Technical Note

Project:	Harlington School, Pinkwell Lane, Hayes UB3 1PB		
Prepared by:	S. Pond	Date:	19 August 2024
Approved by:	A. Watts	Checked by:	A. Watts
Subject:	Preliminary Remediation Validation	Ref:	737604-1(00)

TITLE: Figure 2:
Exploratory Hole Location Plan

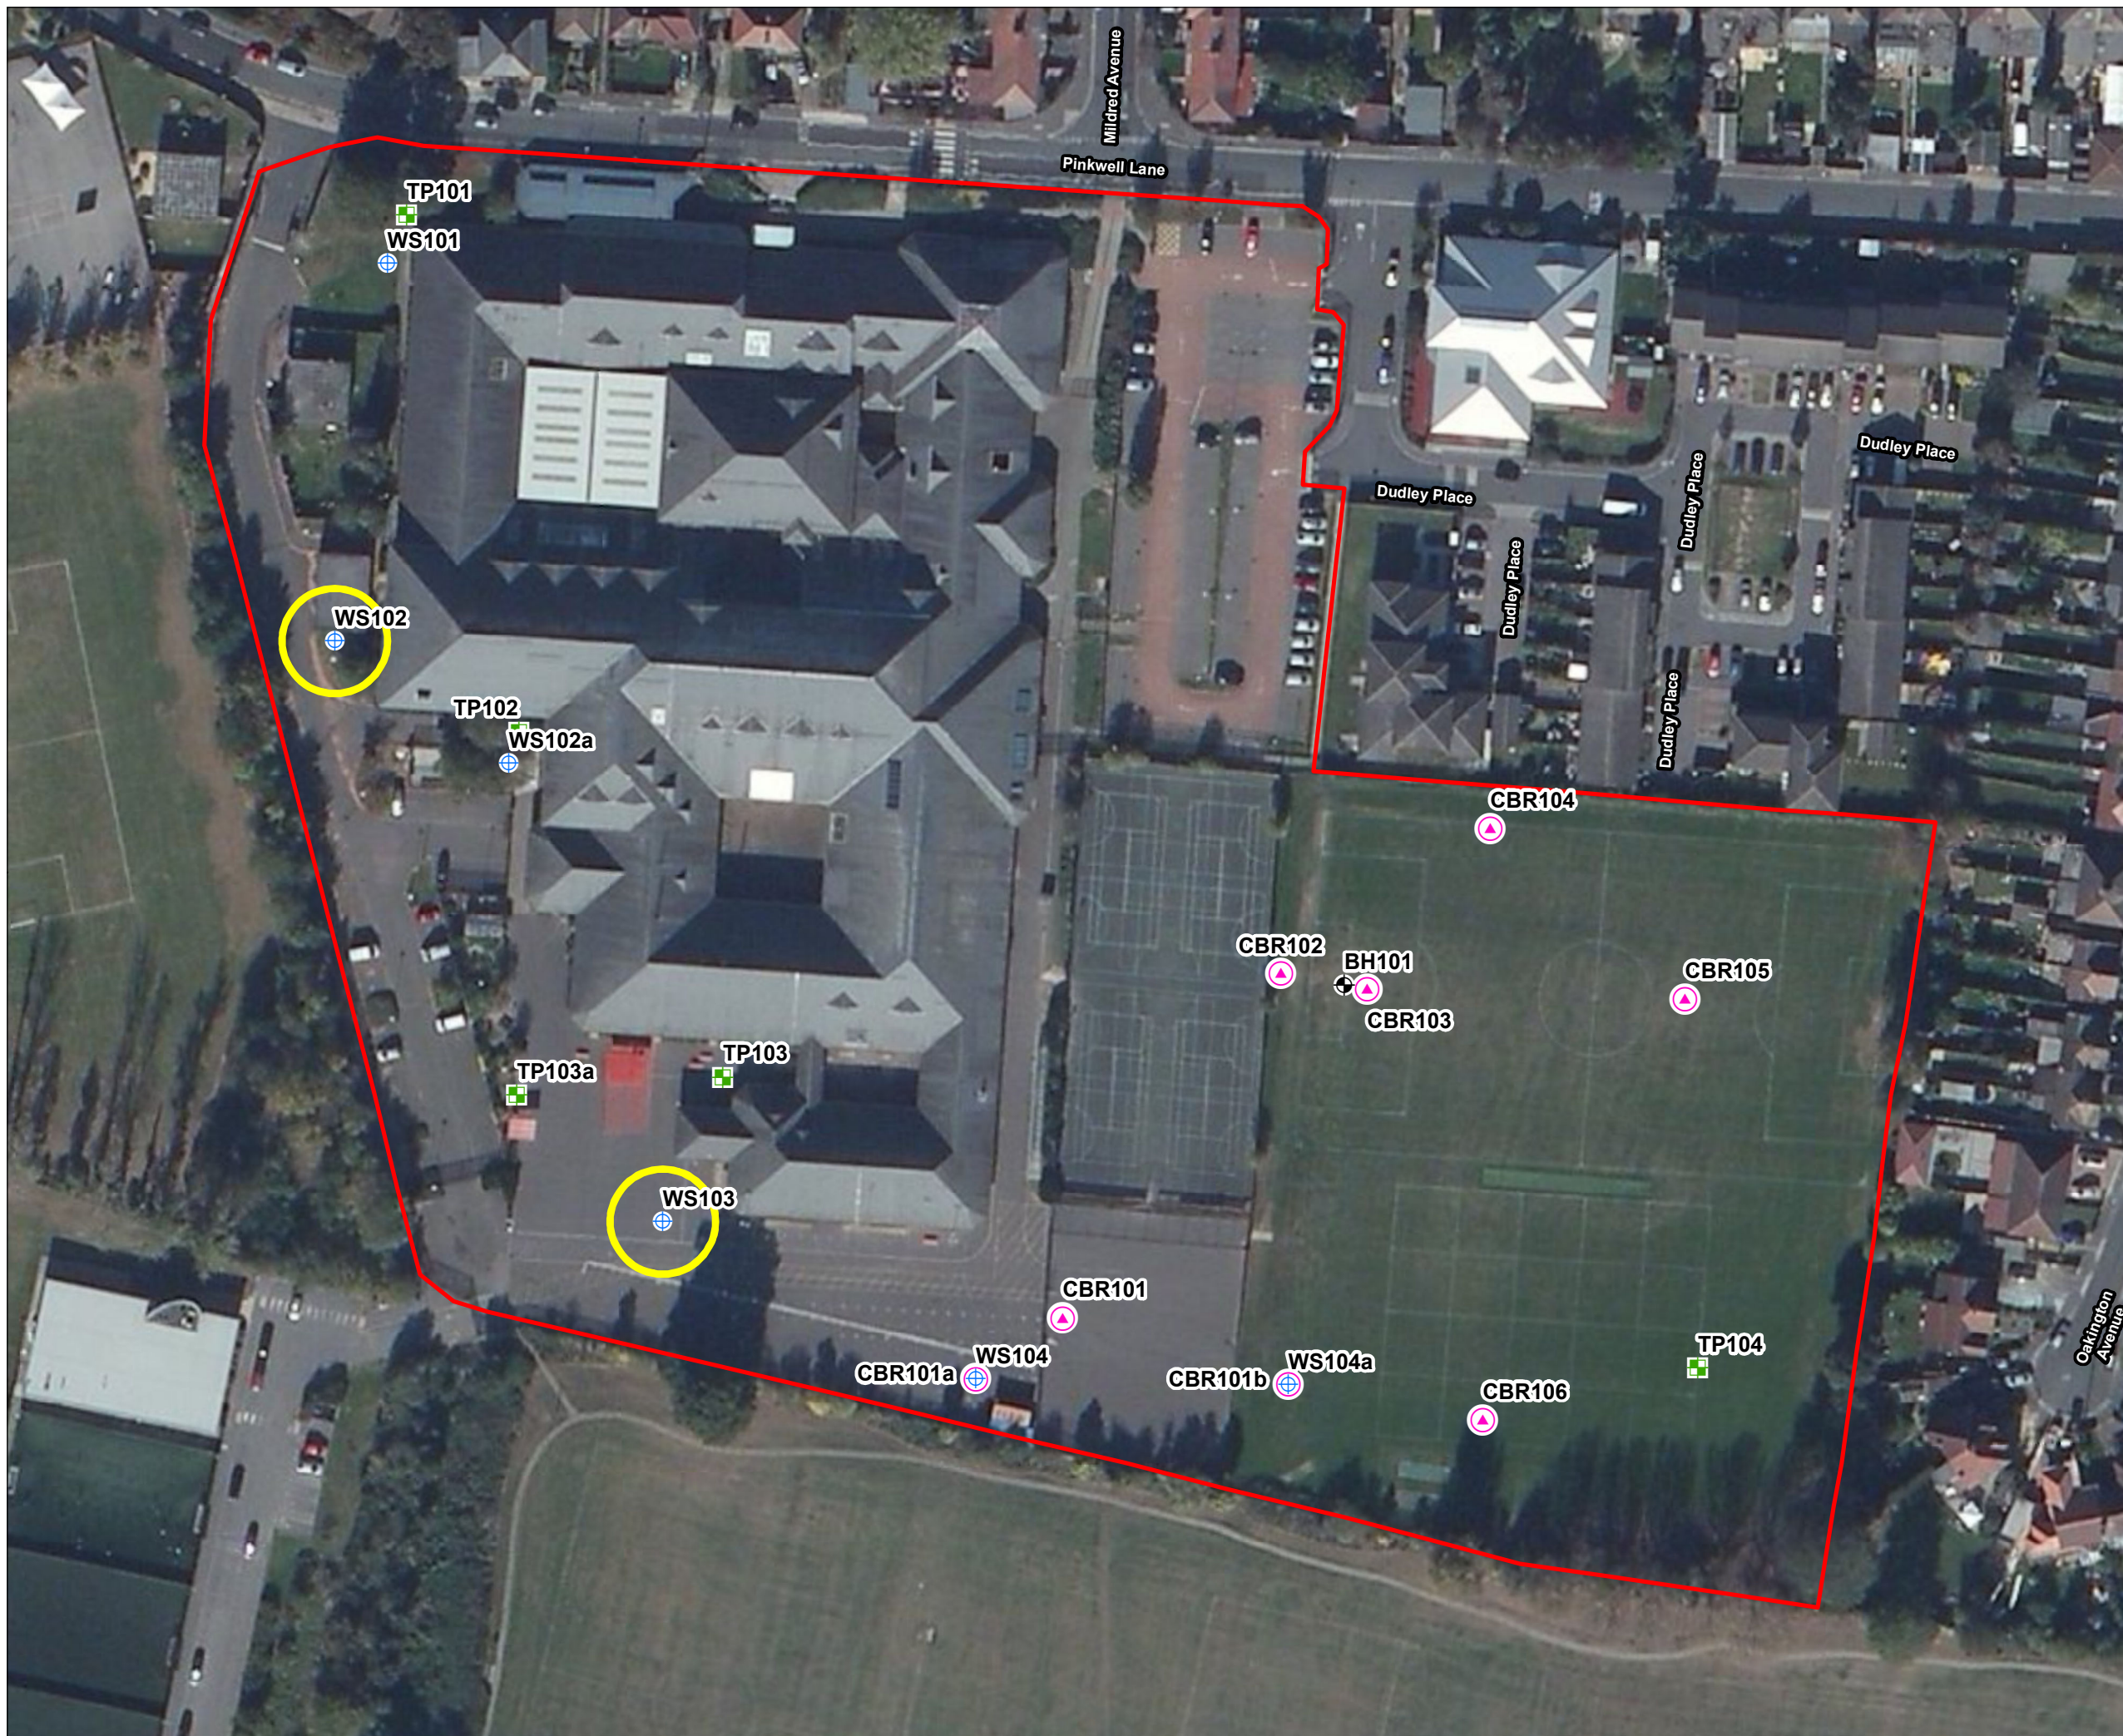
WS102 is set within a 9 m by 12 m area grassed area of soft landscaping which is to be retained and falls within the red-line boundary. It has become apparent that site constraints in the vicinity of WS102 mean that delivery of this approach is not practicable due to the presence of a protected tree with Wates (Principal Contractor) reporting a conflict between the required excavation for source removal and the root protection zone for this tree.

Wates have consulted with their arboricultural consultants and now propose an alternative method of remediation to be used across the whole 12 m by 9 m area of soft landscaping to break the pathway and remove the potential contaminant linkage.

This would be accomplished by carefully removing the existing turf to minimise damage to the tree roots and then applying a proprietary bonded granular rubber mulch (<https://www.abacuspg.co.uk/bonded-rubber-mulch/>). This would be fully permeable to water and air and durable with the appearance of shredded wood bark mulch. The mulch layer would prevent exposure of site users and the public to the site soil, without damaging the roots of the tree.

Validation of the remediation of this area could then be achieved by the contractor supplying photographs of the finished area, a delivery note or invoice for the rubber mulch material, and waste characterization and disposal documentation for the removed turf.
